## Waste Management Facility, Botany

Integrated Water Management Strategy

**Coombes Property Group Pty Ltd**

A response to this submission was provided by Bayside Council (their ref: SSD-2024/10) dated 09/09/2024 – and the response to their civil engineering queries is summarised below (note flood and landscape related queries are responded to in other respective reports):

Project		HALE STREET, BOTANY		Drawing Title		STORMWATER MUSIC CATCHMENT PLAN	
Client		COOMBES PROPERTY GROUP		Drawn By		TS	
Project Number		15146		Checked By		BW	
Zone		00		Drawn Scale		1:250 @ A1	
Level		00		Date of first issue		28.08.25	
File Type		DWG		Revision		A

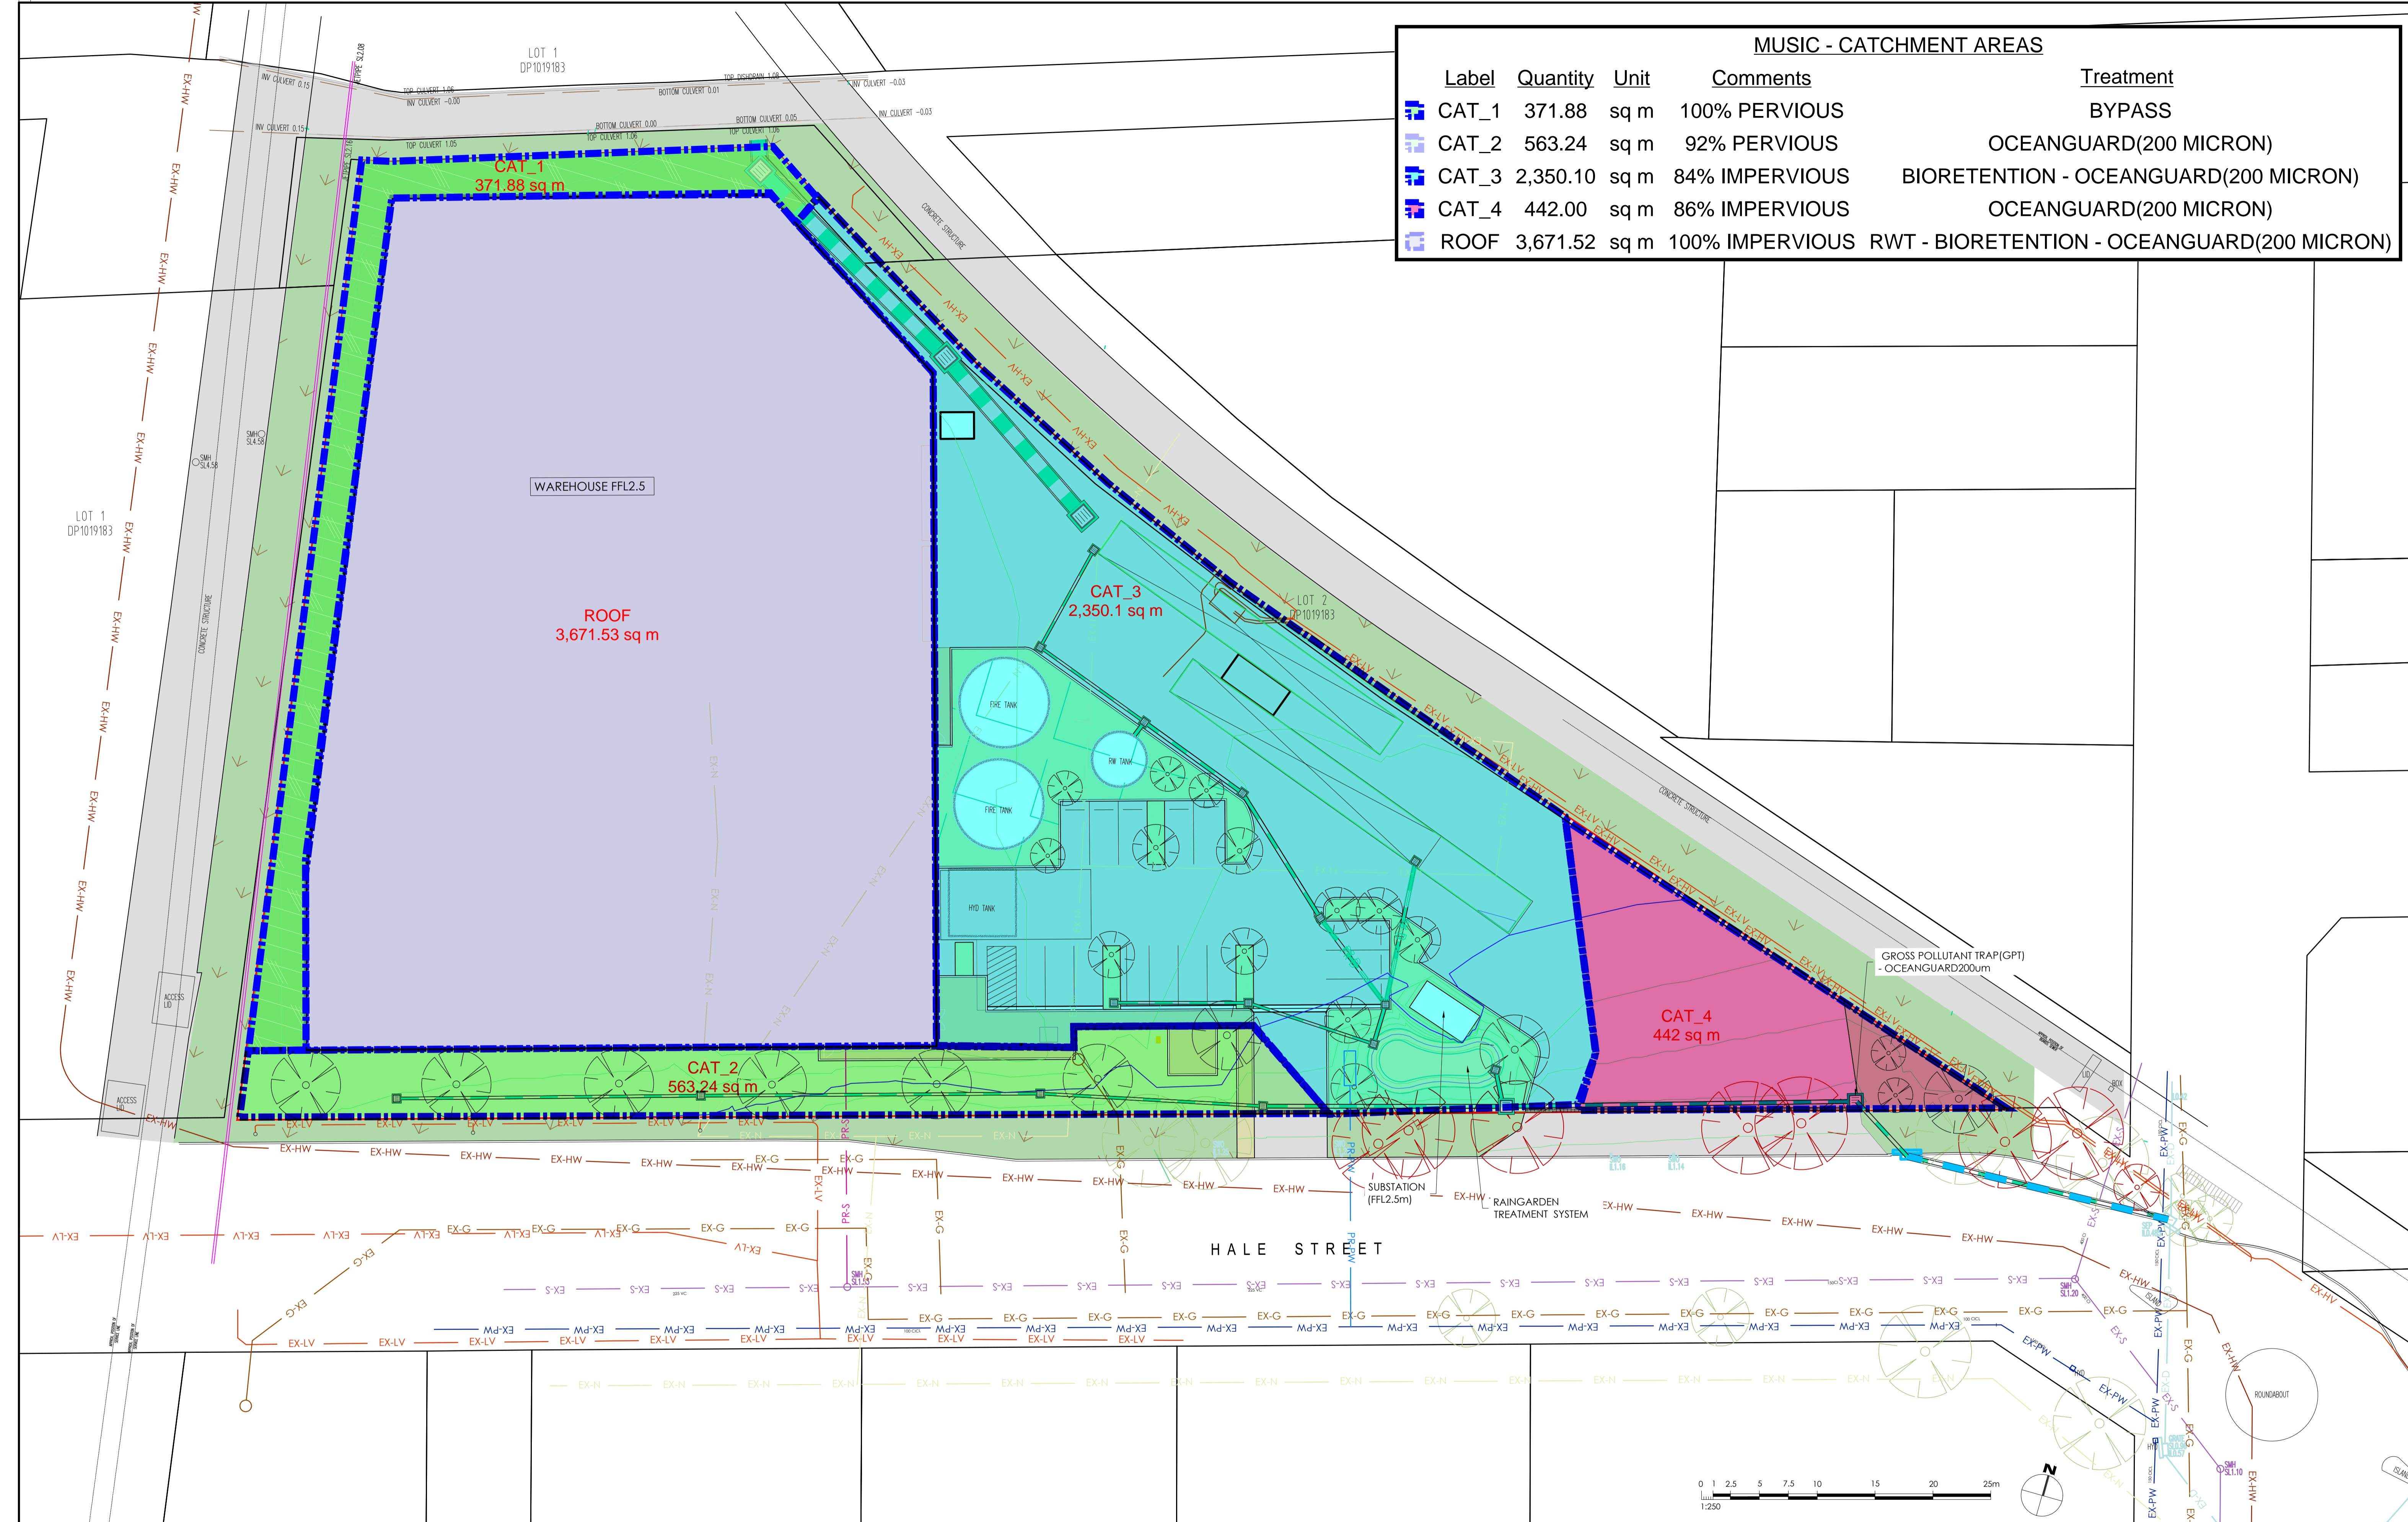
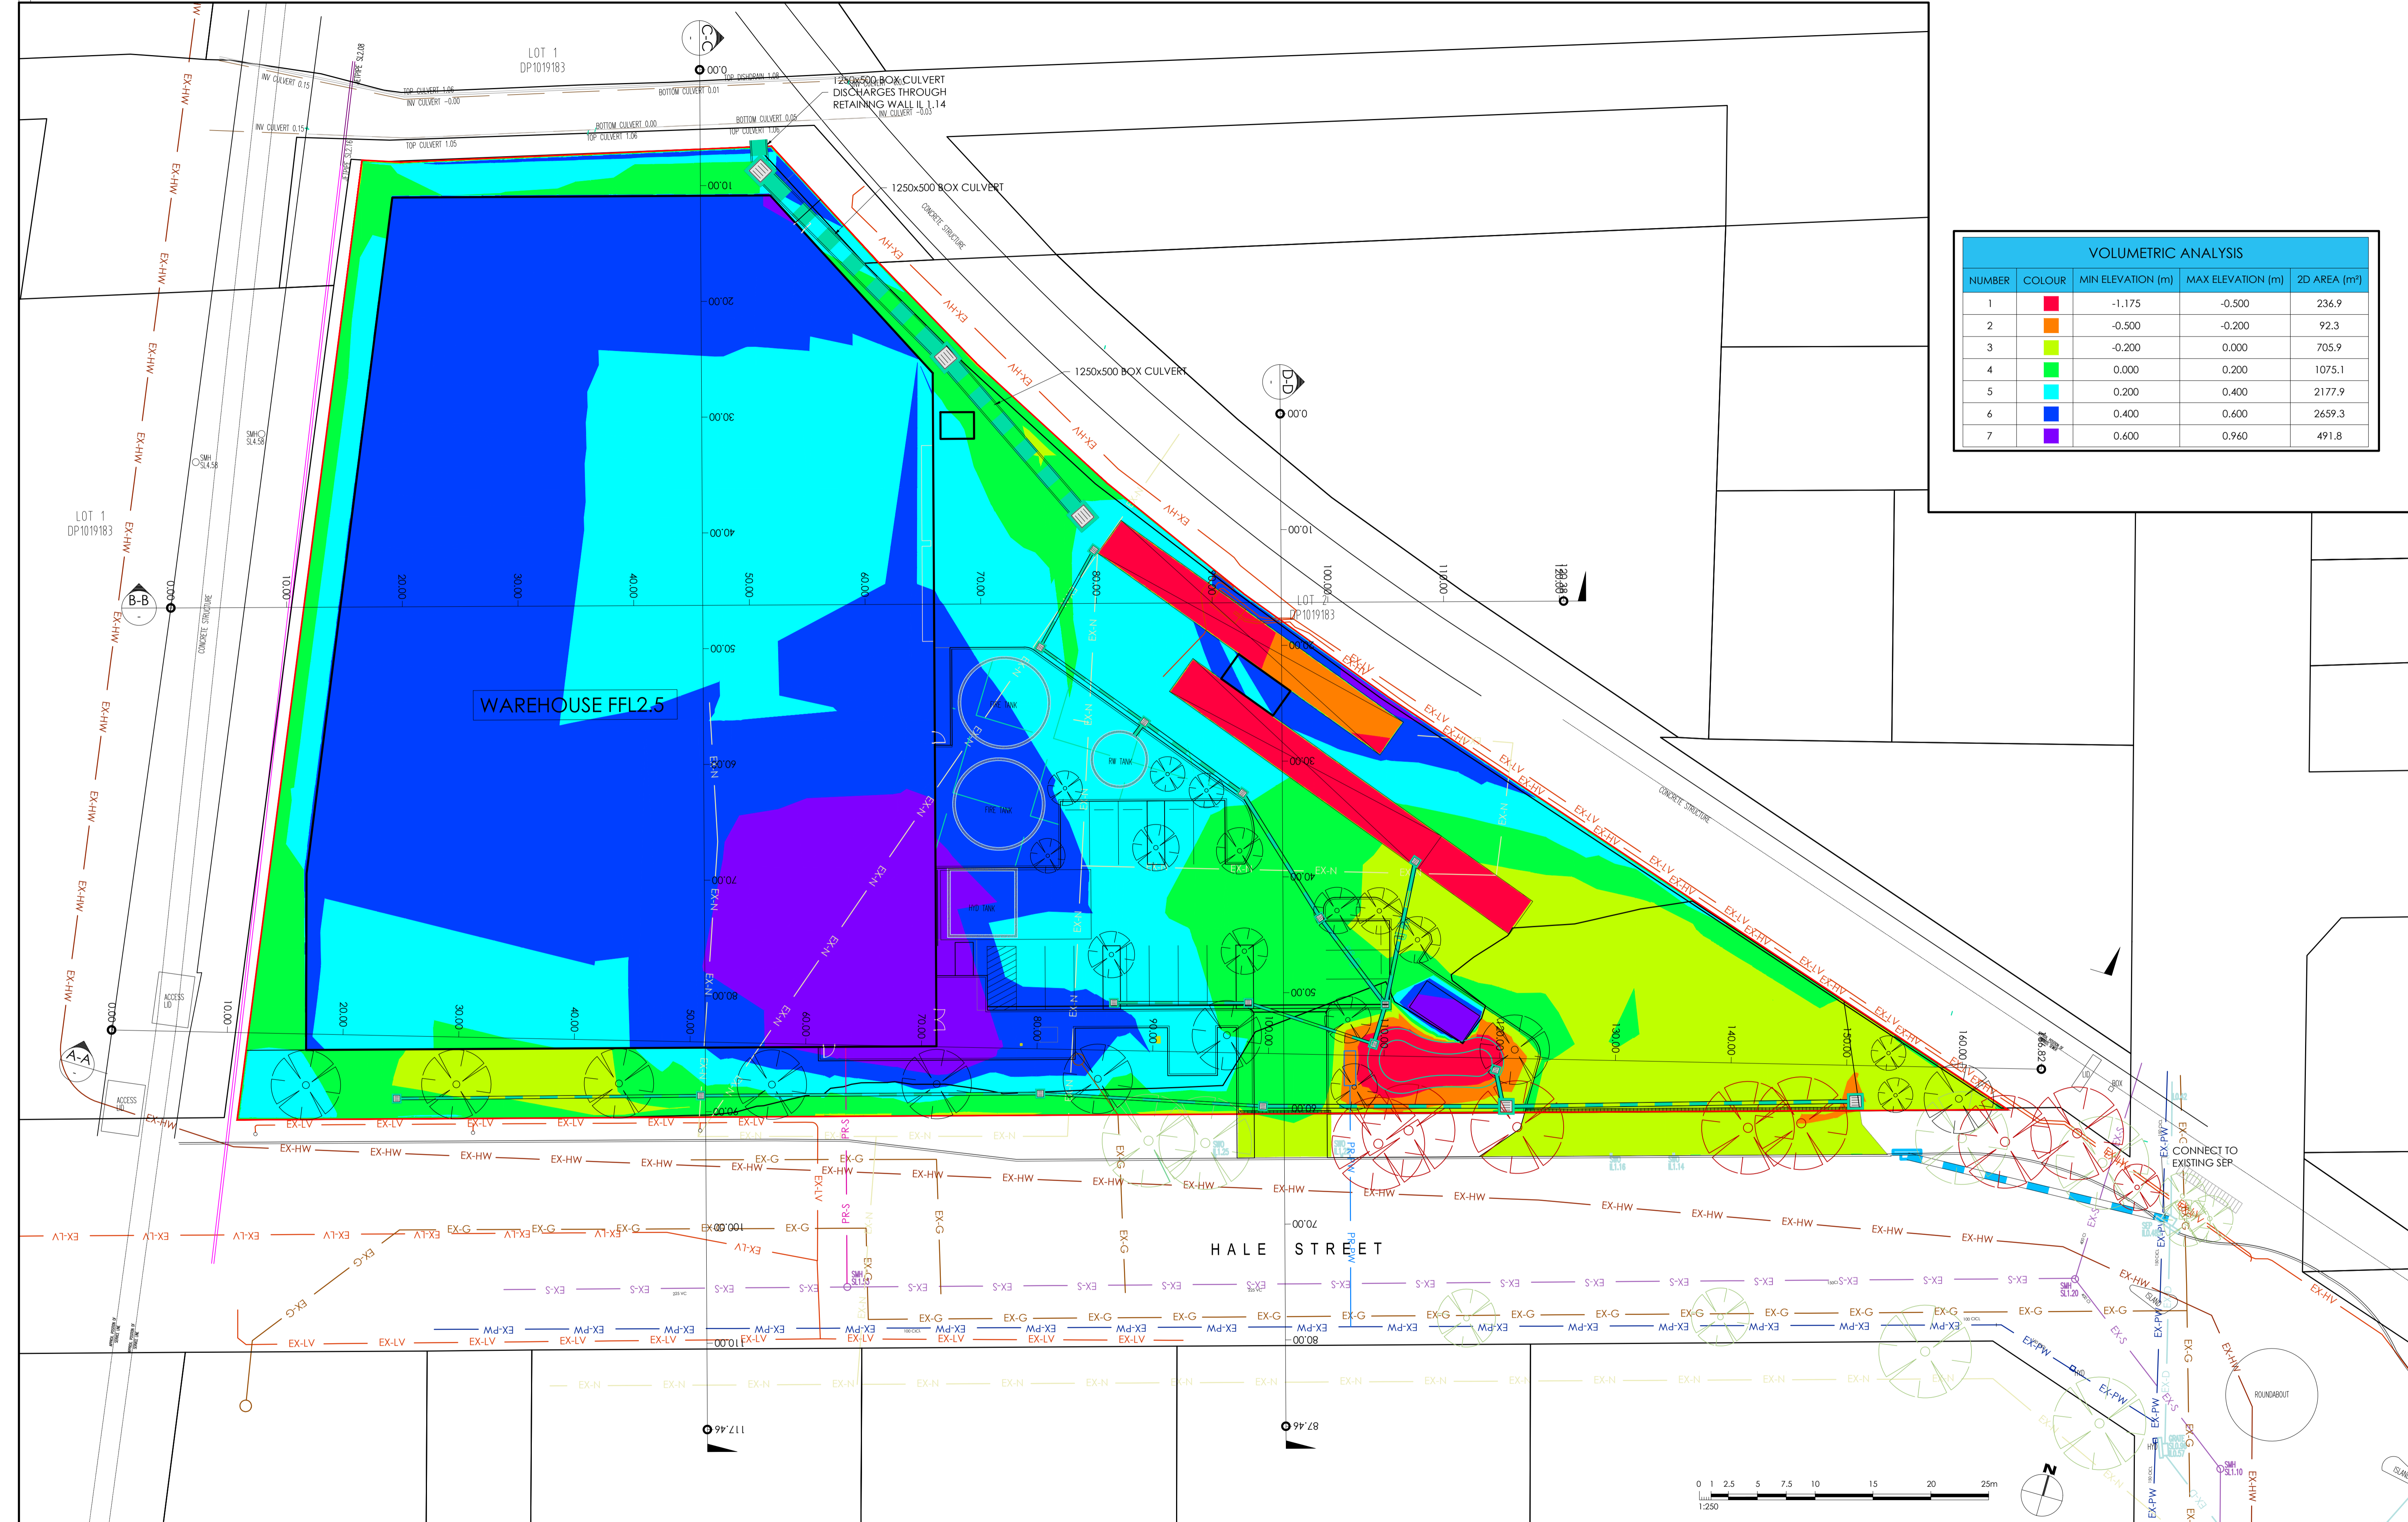
<p>Furthermore, figure 5 of this report cannot be assessed as it does not include the areas of each catchment and is not supplemented by stormwater plans verifying the catchment areas and demonstrating the treatment train is feasible.</p>	<p>Refer to Table 4 on Section 5.8 and Catchment area plan in Appendix C</p>	<p>Section 5.8: Table 3; Appendix C</p>
<p>The parameters of the bioretention system in the MUSIC model shall be shown. The bioretention system appears to be overperforming and it’s not clear how the site will effectively capture gross pollutants from impervious areas. Furthermore, it needs to be detailed how this system will work given the substation and trees proposed in this area.</p>	<p>This is included in the soft copy of the MUSIC file provided for council review.</p>	<p>Attached .sqz file</p>
<p>A soft copy of the amended MUSIC modelling shall be provided.</p>	<p>As above</p>	<p>Attached .sqz file</p>
